WEST SUSSEX COUNTY COUNCIL CONSULTATION

TO:	<u>Arun</u> District Council <u>FAO:</u> Mrs. A. Gardner
FROM:	<u>WSCC</u> – County Highways Authority: Tim Townsend
DATE:	6 th September 2019
LOCATION:	Land At <u>Toddington</u> Farm North And West Of 1 To 3 <u>Toddington</u> <u>Toddington</u> Lane <u>Littlehampton</u> <u>BN17 7PN</u>
SUBJECT:	<u>LU/248/19/DOC</u> Approval of details reserved by condition imposed under ref APP/C3810/W/18/3197149 (LU/162/17/PL relating to Condition Nos 8 - materials & finishes, 9 - landscaping scheme, 10 - Construction Management Plan, 13 - visibility splays, 14 - pedestrian visibility plays, 16 - cycle parking and 18 - street lighting.
DATE OF SITE VISIT:	n/a - for purposes of this specific planning application.
RECOMMENDATION:	More information required
S106 CONTRIBUTION TOTAL:	n/a for purposes of this specific planning application.

This is the WSCC County Highways (CHA) response to the above planning application for approval of details reserved by condition imposed under ref APP/C3810/W/18/3197149 (LU/162/17/PL relating to Condition Nos 8 - materials & finishes, 9 - landscaping scheme, 10 - Construction Management Plan, 13 - visibility splays, 14 - pe

Construction Management Plan Layout

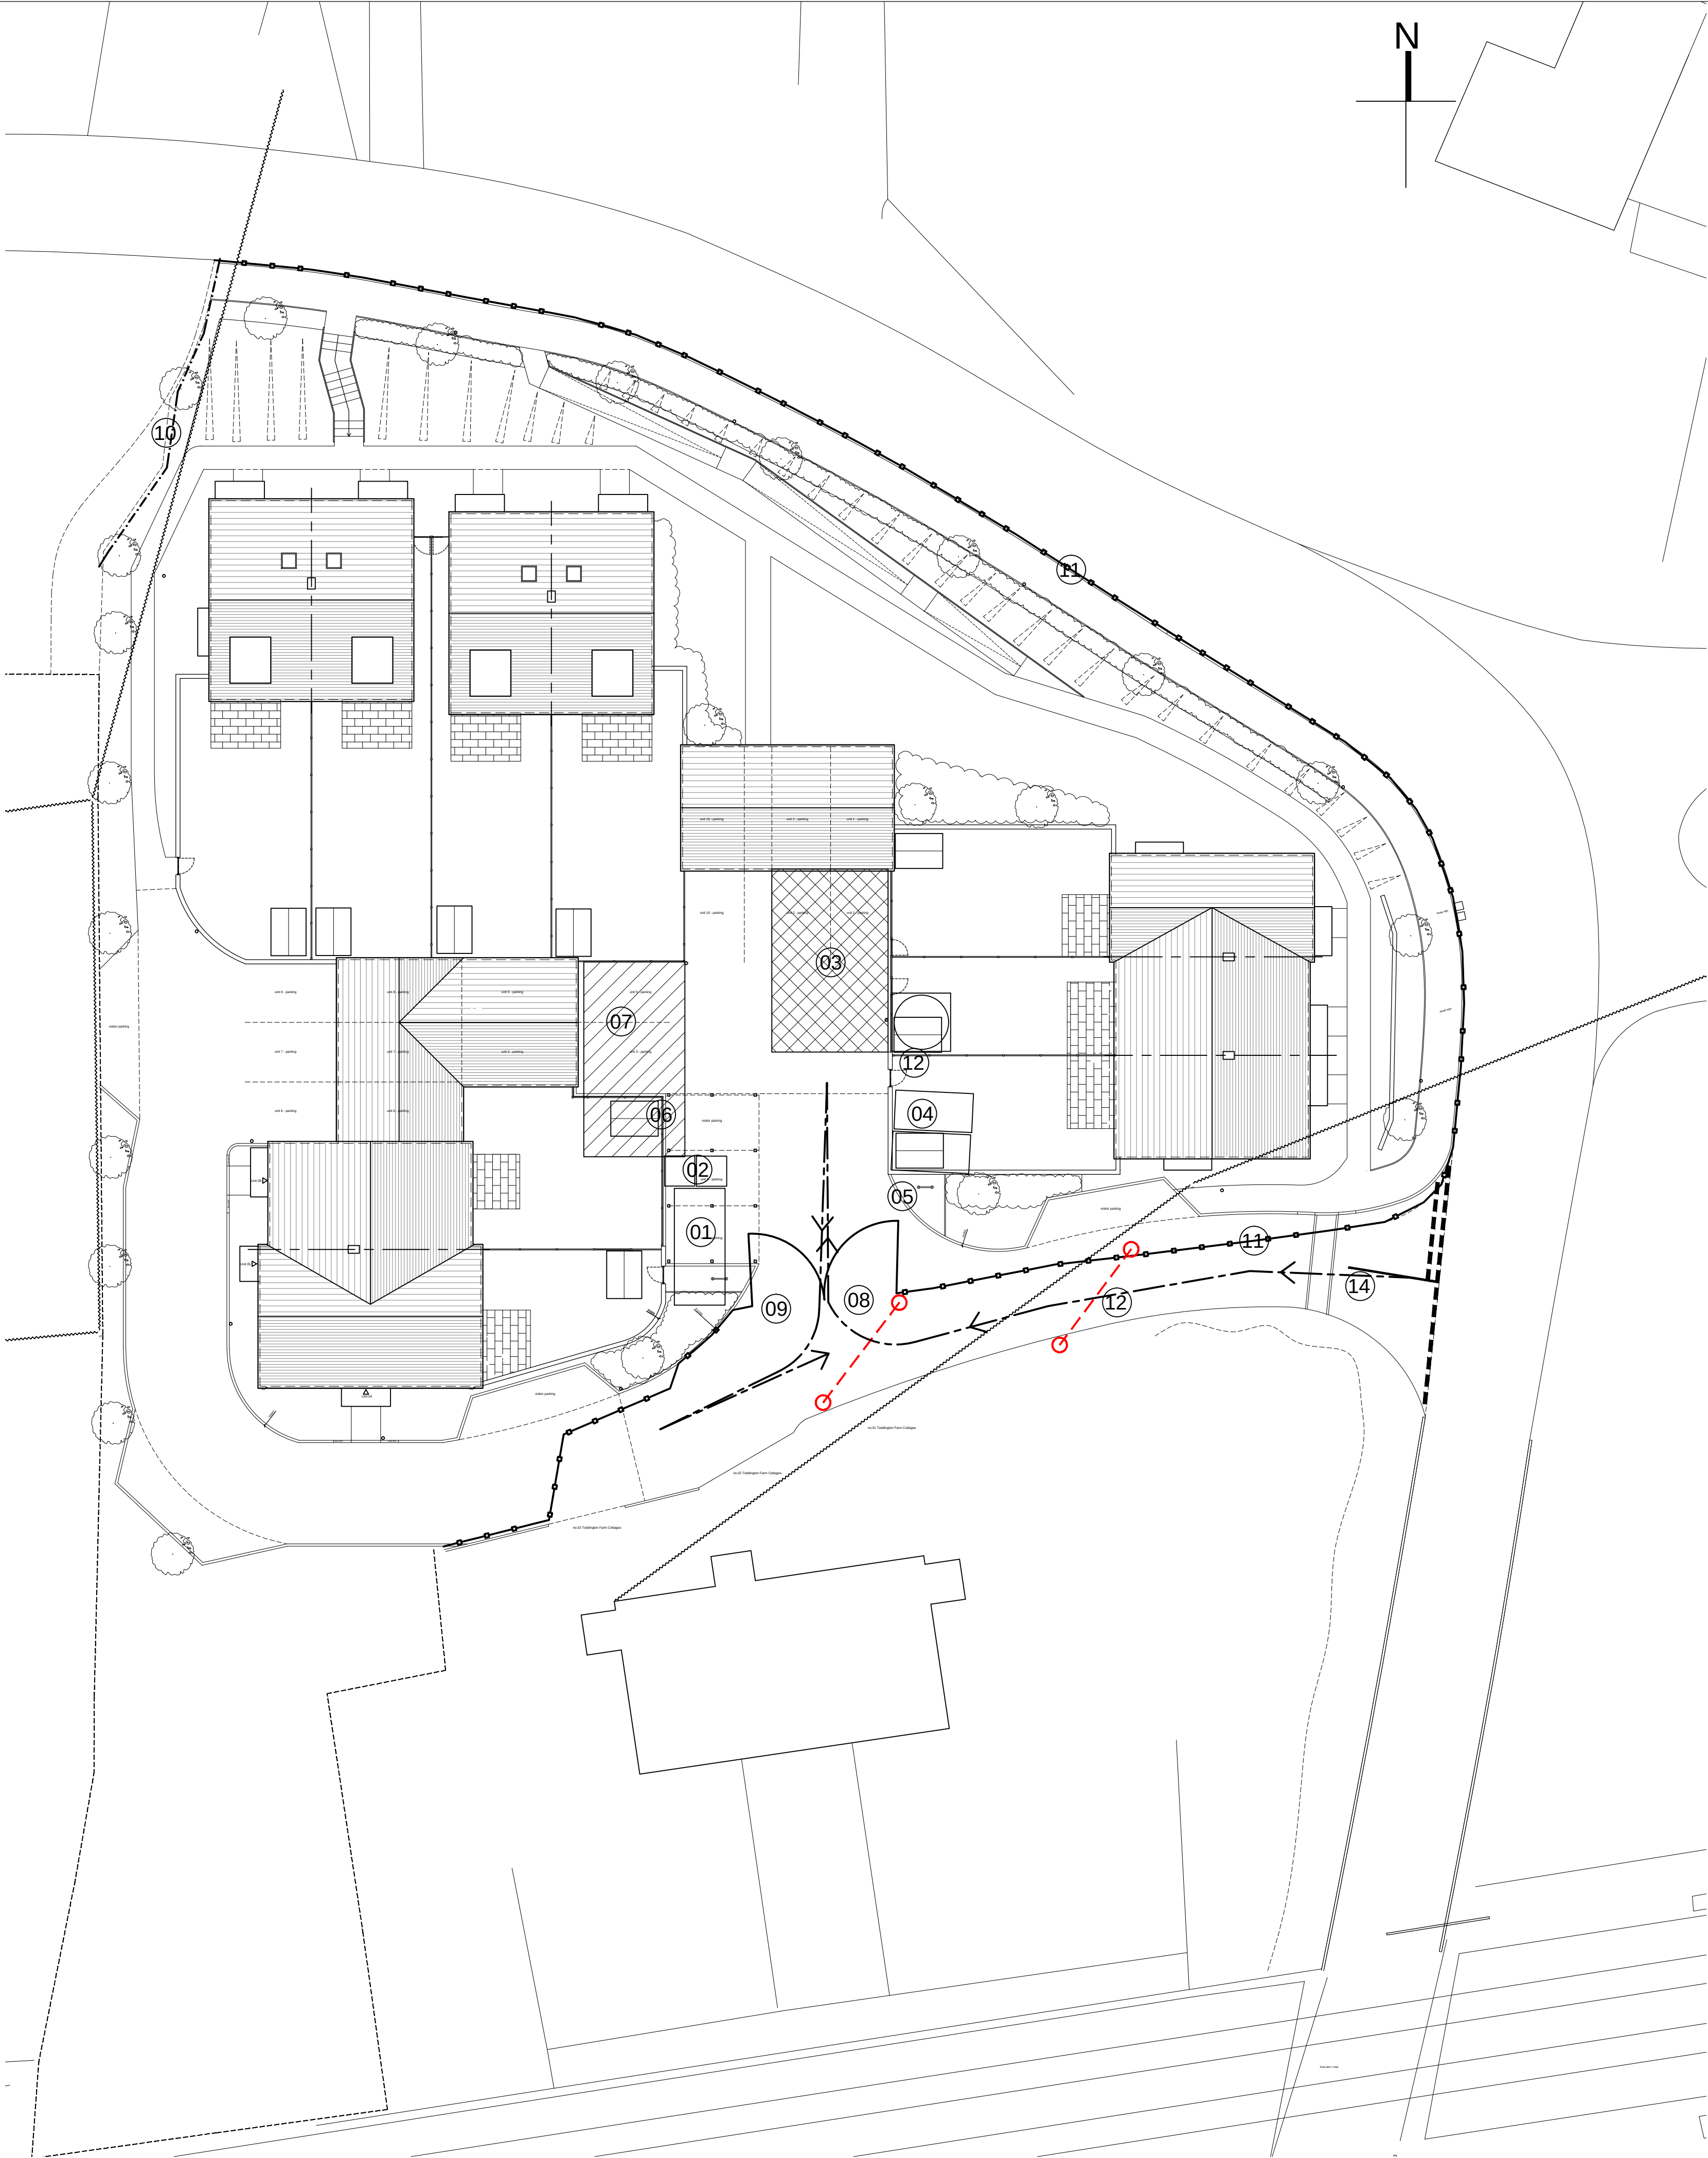
3. Condition 10 (Construction Management Plan) – The following items should be added to the CMP:
 - Construction routing plan to demonstrate no access to or from the south. All deliveries to enter from and leave to the north to avoid Toddington Lane and the adjacent railway crossing.

- A plan showing parking for contractors and visitors on the site clear of the public highway.
 - A plan showing areas for materials storage on the site and clear of the public highway.

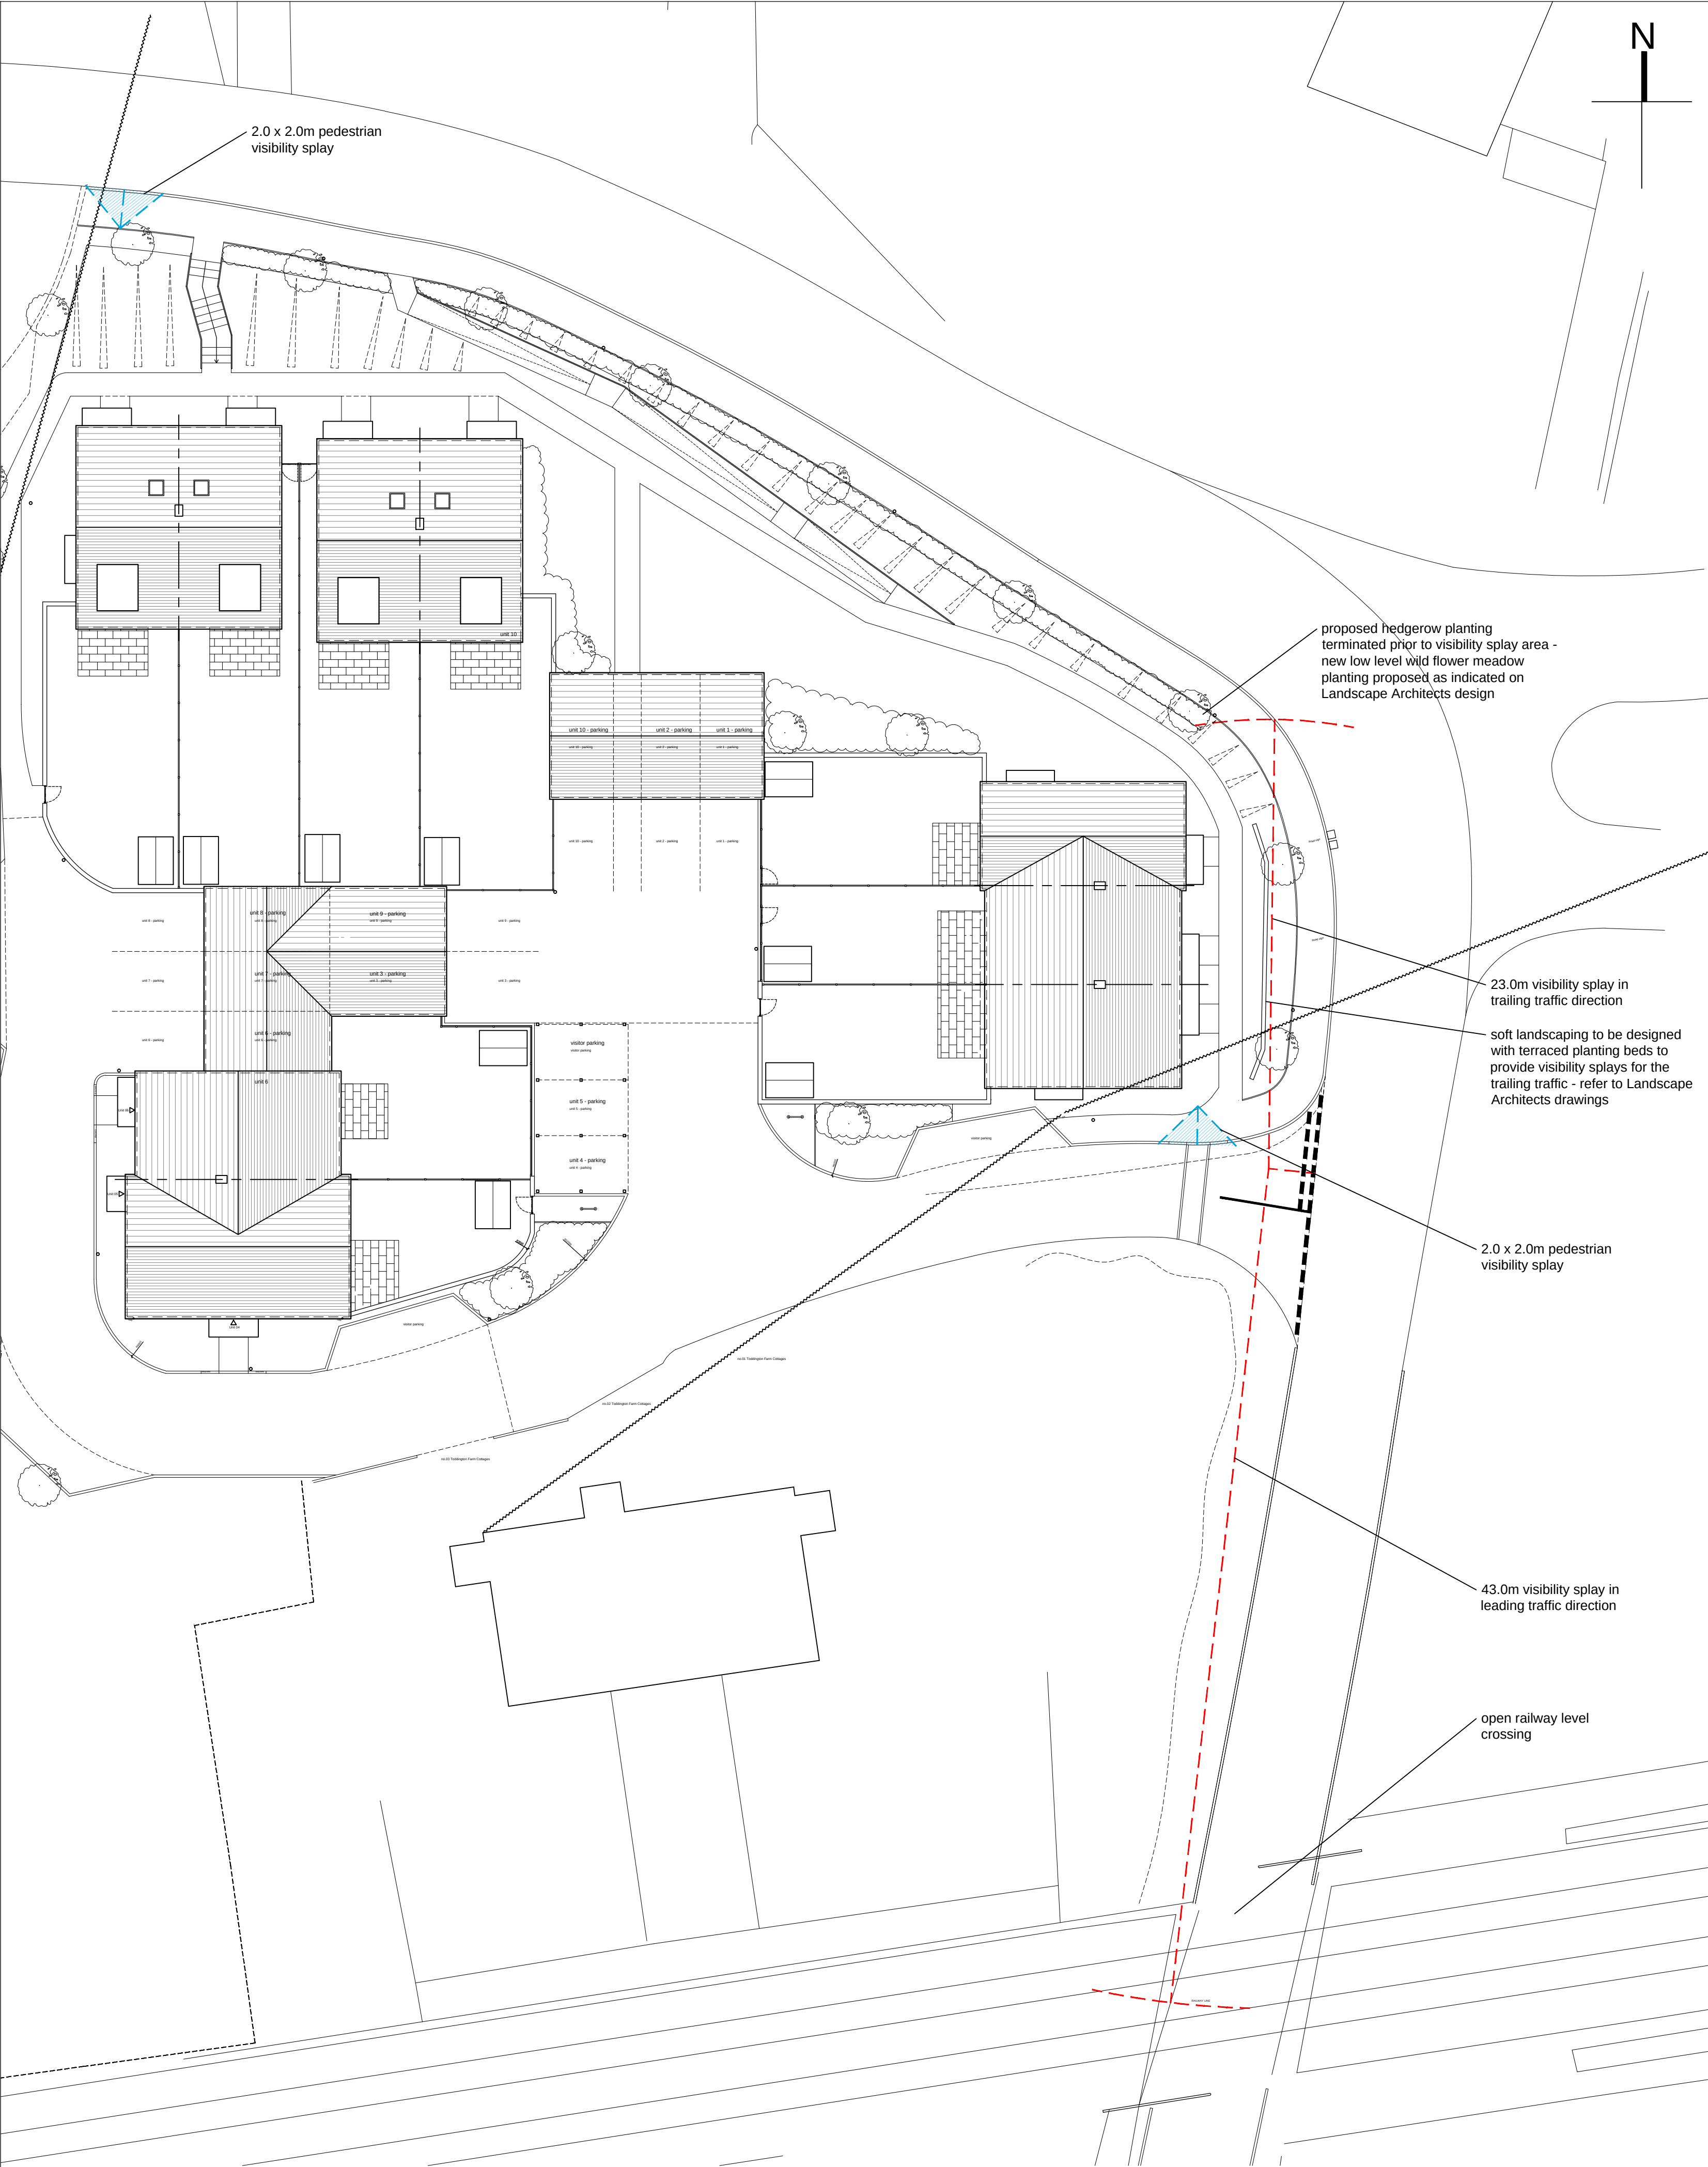
4. Condition 13 (visibility splays) – The splay in the leading traffic direction (so looking south from the access point) appears acceptable. However, the one to the north (so trailing direction) only measures 23m. It is recommended that it be extended back into the site and then shown extending further northwards into the carriageway. Also, some form of structure appears to be shown in front of plots 1-3 which is on public highway. No structure would be permissible on highway land. Further details required.

5. Condition 14 (pedestrian visibility splays) – The pedestrian visibility splays are shown incorrectly. They should be provided where access points (vehicular and pedestrian) emerge to the back-edge of any footway (i.e. the stairs and ramp). A further splay (suitable for peds/motorists) should be shown at the western-end of the proposed footway as this is where pedestrians will be interacting with the carriageway given that the footway terminates at this point.
